From: Simon Davis <Simon.Davis@arun.gov.uk>
Sent: 17 February 2020 10:24
To: Planning.Responses <Planning.Responses@arun.gov.uk>
Subject: FW: Nyton Stables, Arun Ref AL/60/19/DOC

From: Rachel Alderson <Rachel.Alderson@arun.gov.uk>
Sent: 14 February 2020 16:58
To: Simon Davis <Simon.Davis@arun.gov.uk>; Rosemarie Dannatt <Rosemarie.Dannatt@arun.gov.uk>
Cc: Karen Liu <Karen.Liu@arun.gov.uk>
Subject: FW: Nyton Stables, AL/60/19/DOC

From: Rachel Alderson <Rachel.Alderson@arun.gov.uk>
Sent: Friday 14 February 2020 09:51
To: Eamonn Prenter [REDACTED]
Cc: Emma Oldroyd [REDACTED]
Subject: RE: Nyton Stables, Arun Refs. AL/60/19/DOC

DRAWING NO: **18307-2-103 RevG**

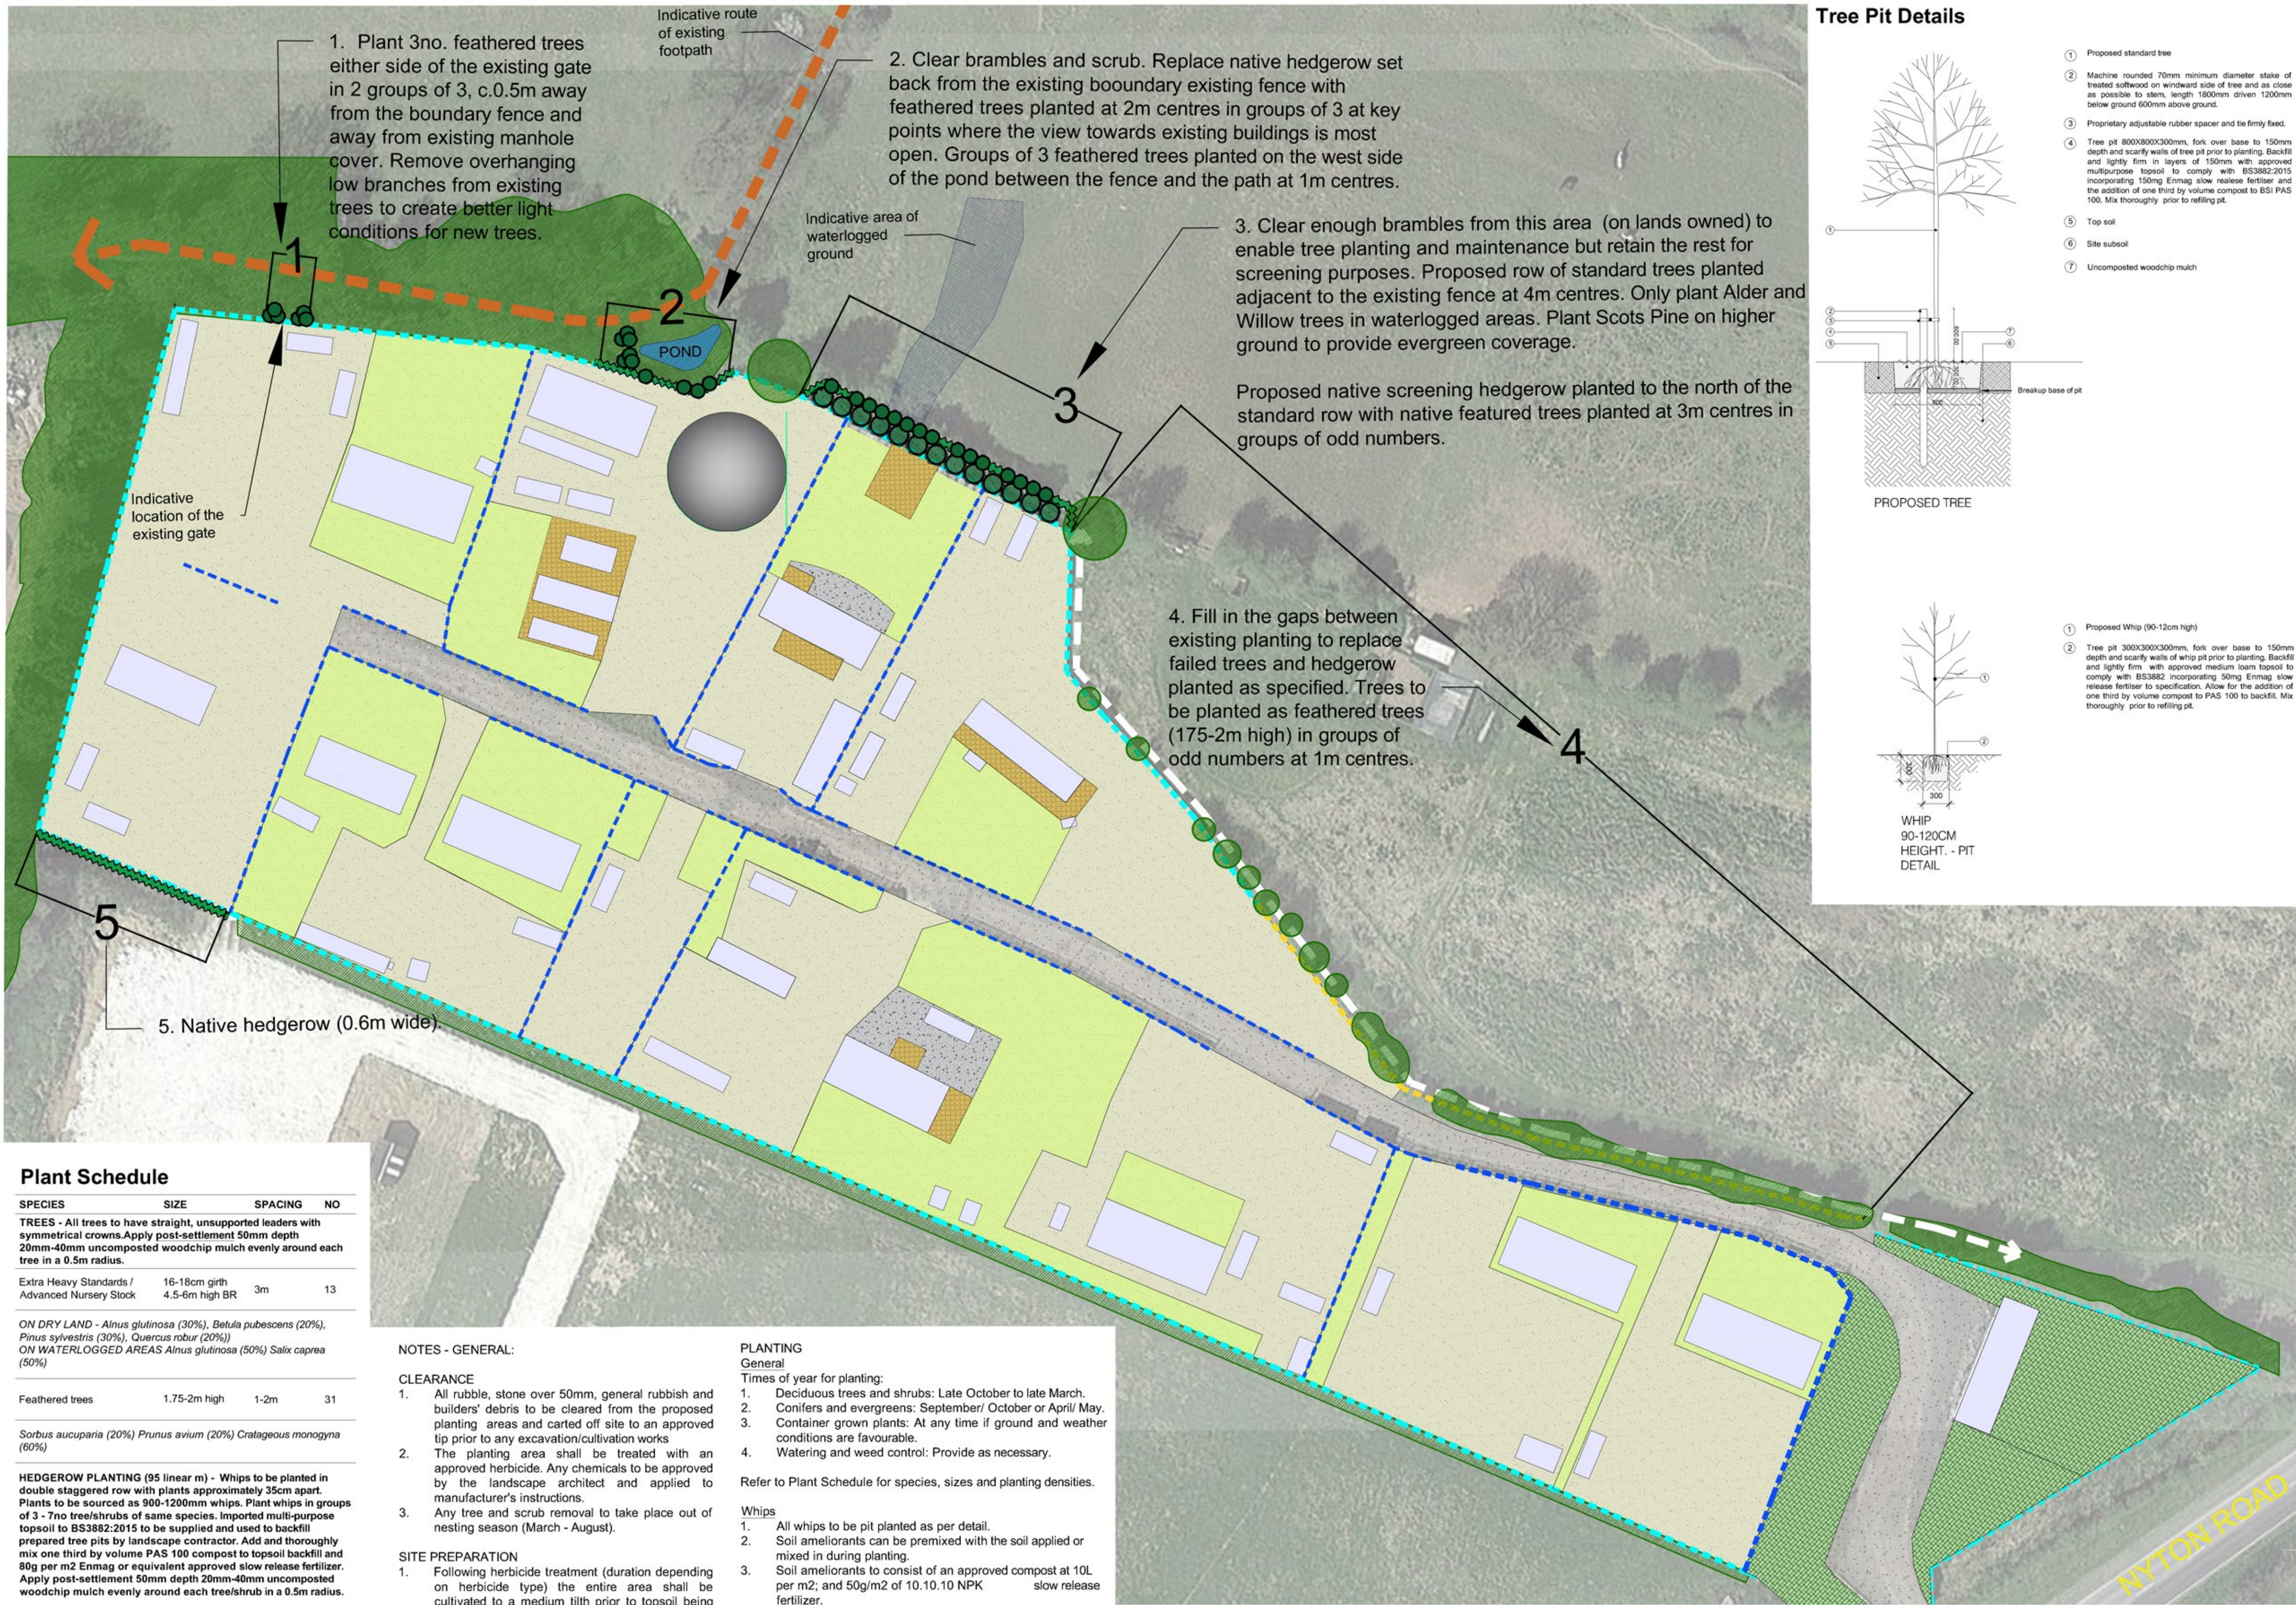
I have just quickly reviewed the planting mix at Section 3 in more detail. I would prefer that the Pinus is 30% of the mix just to give that extra degree of evergreen screening and reduce the Quercus to 20%. Otherwise yes I am happy to sign this off taking on board my comments below.
